Recommendation Report for Planning Permission for Works or Extension to a Dwelling

REF NO: AL/47/20/HH

LOCATION: 12 Lime Avenue
Aldingbourne
PO20 3UF

PROPOSAL: Removal of existing garden fence and reinstatement of same on western boundary of the property.

12 Lime Avenue - PROPOSED FENCE LINE
MARKED IN RED.

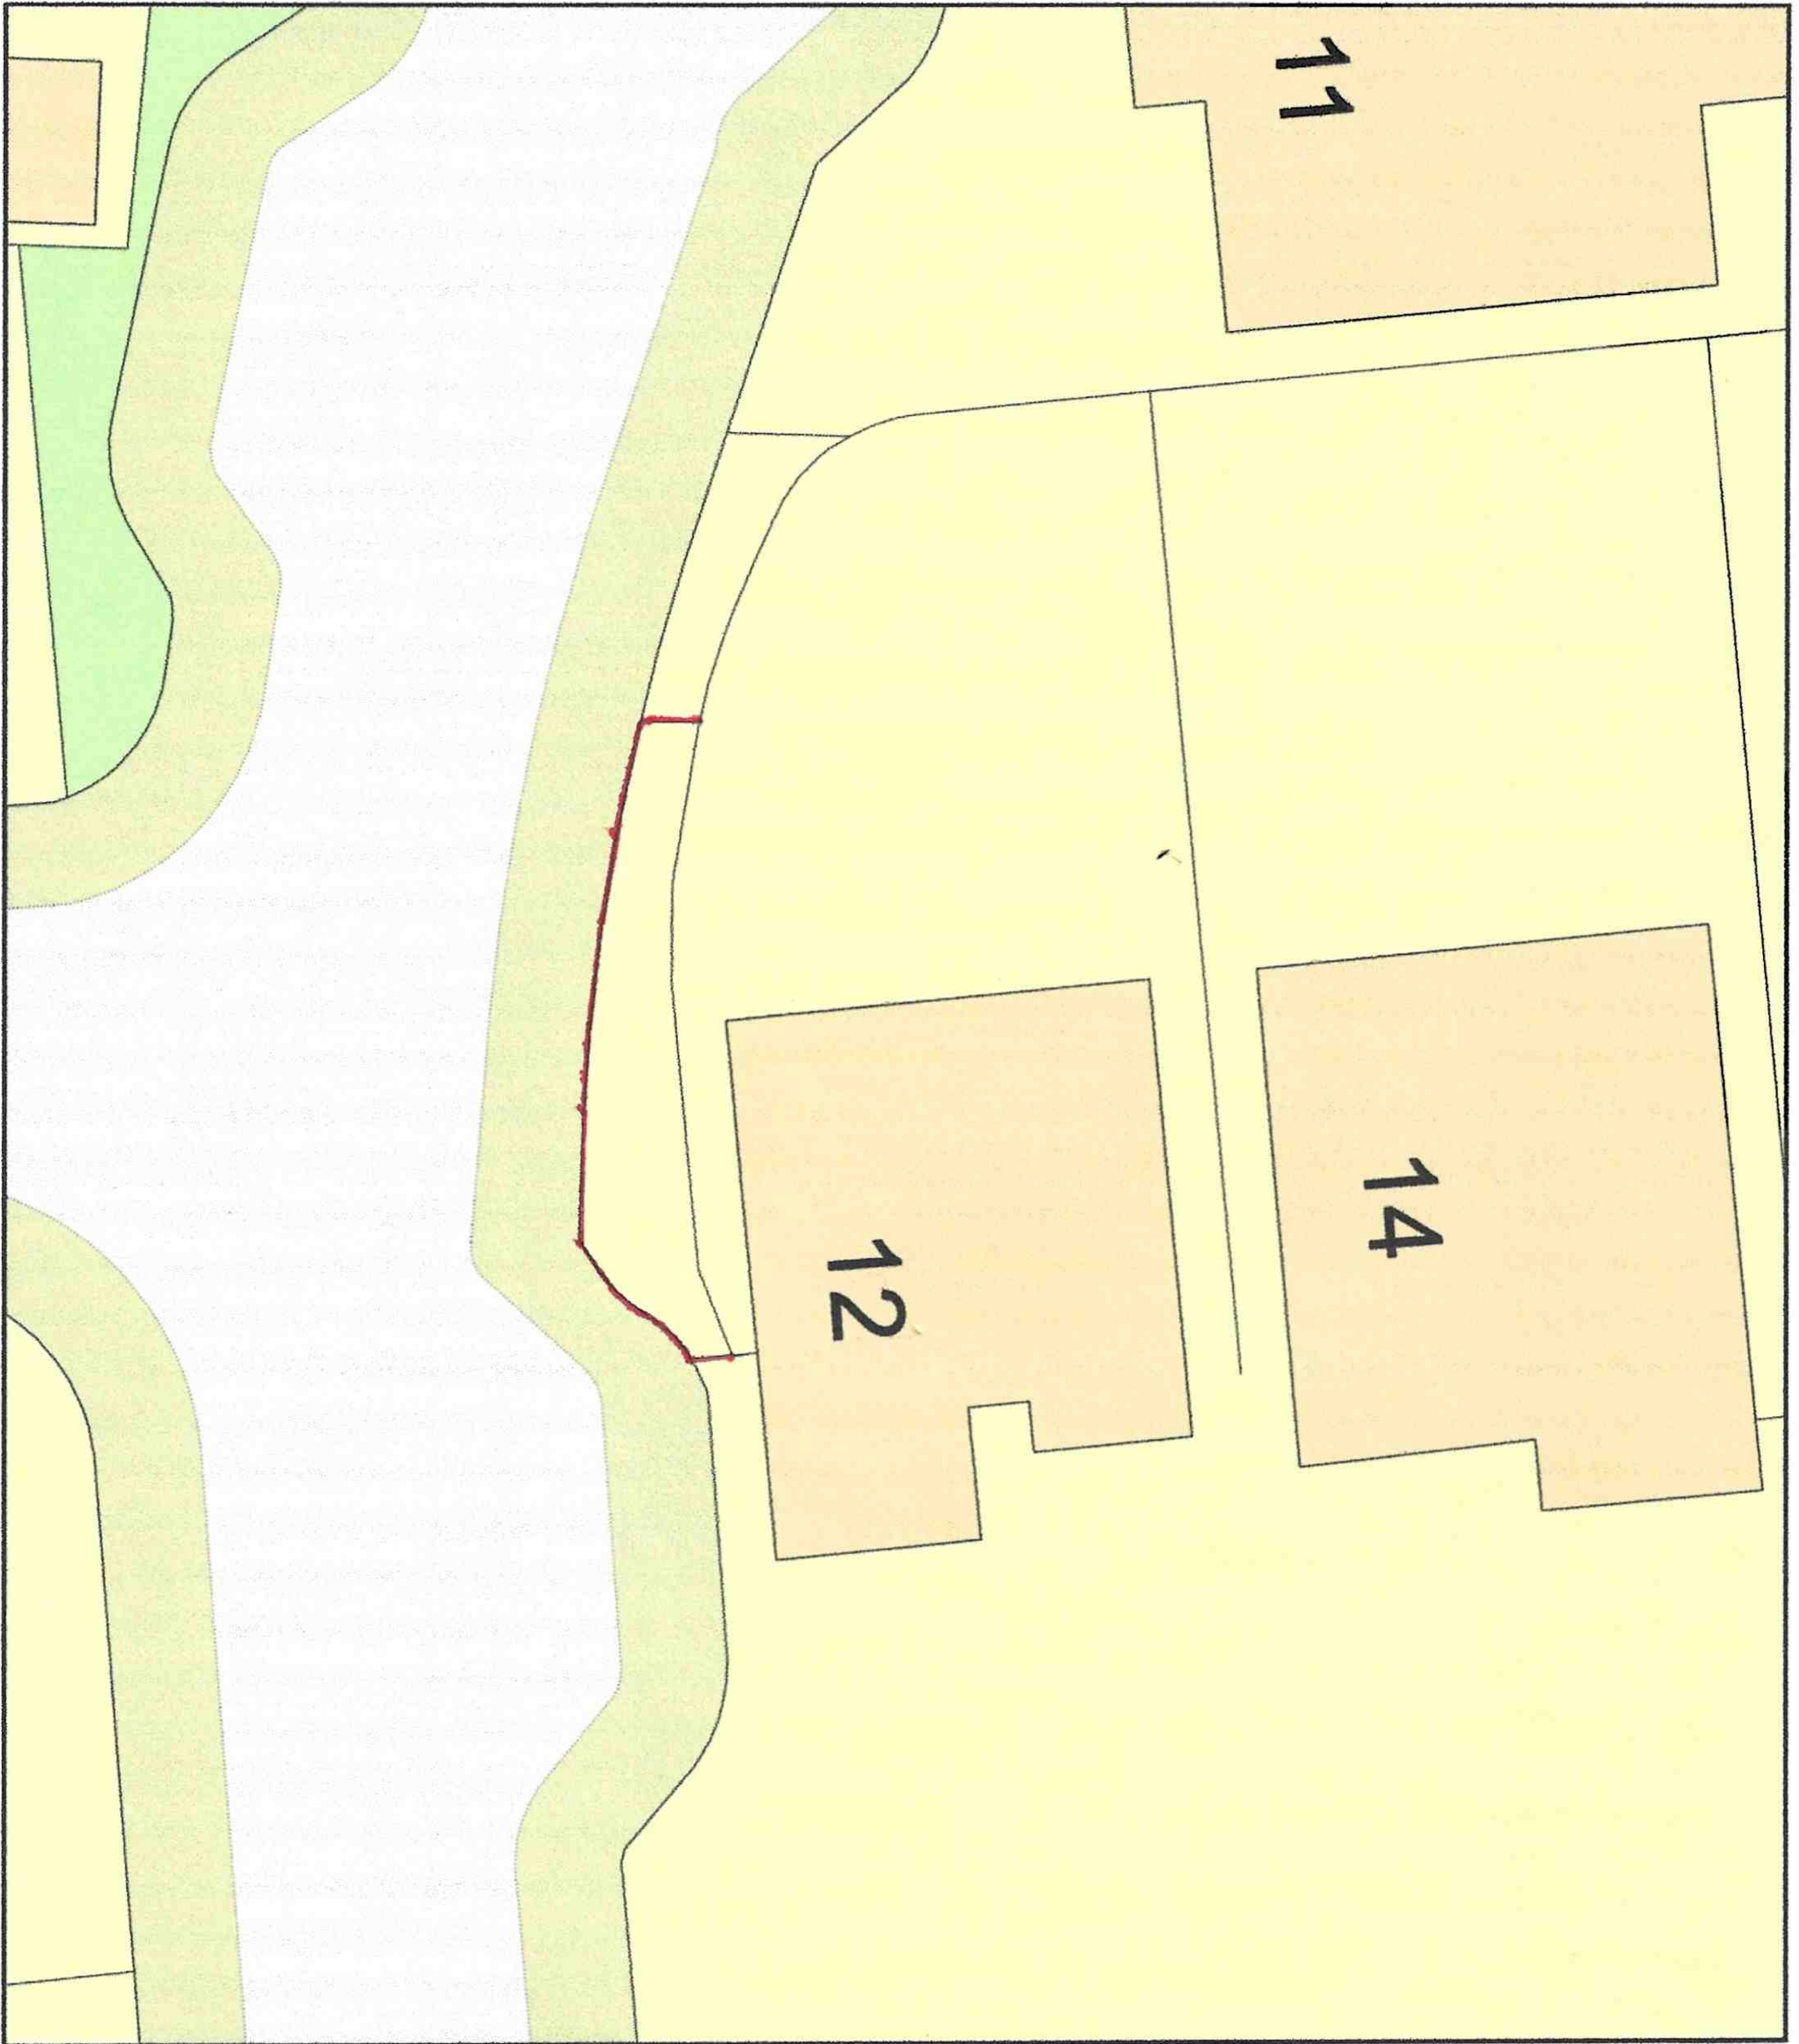
The proposal seeks to remove an existing fence to the side boundary of the property and replace it however it will move slightly further to the west essentially incorporating the grass verge running alongside the property. The fence will have a height of approximately 1.8m.

There is existing planting to the front of the existing wooden fence and therefore the fence is mostly restricted from view.

There are fences visible in the area and nearby properties situated to a corner such as that at No.32 have a fence along the boundary and therefore, the proposal isn't considered to appear out of character for the area.

Whilst the proposal will slightly alter the appearance of the street scene by removing some of the greenery(which does not need permission), the fence is already present and it is not considered the change is such that it will adversely impact the appearance of the street scene in which a refusal is justified. It is therefore considered to comply with D DM1 of the Arun Local Plan.

The fence is situated to western boundary which runs alongside the road. Due to the type of development proposed and its siting and height at 1.8m which is the same as existing, it is not considered to result in adverse impacts upon amenity and accord with D DM1 of the Arun Local Plan.
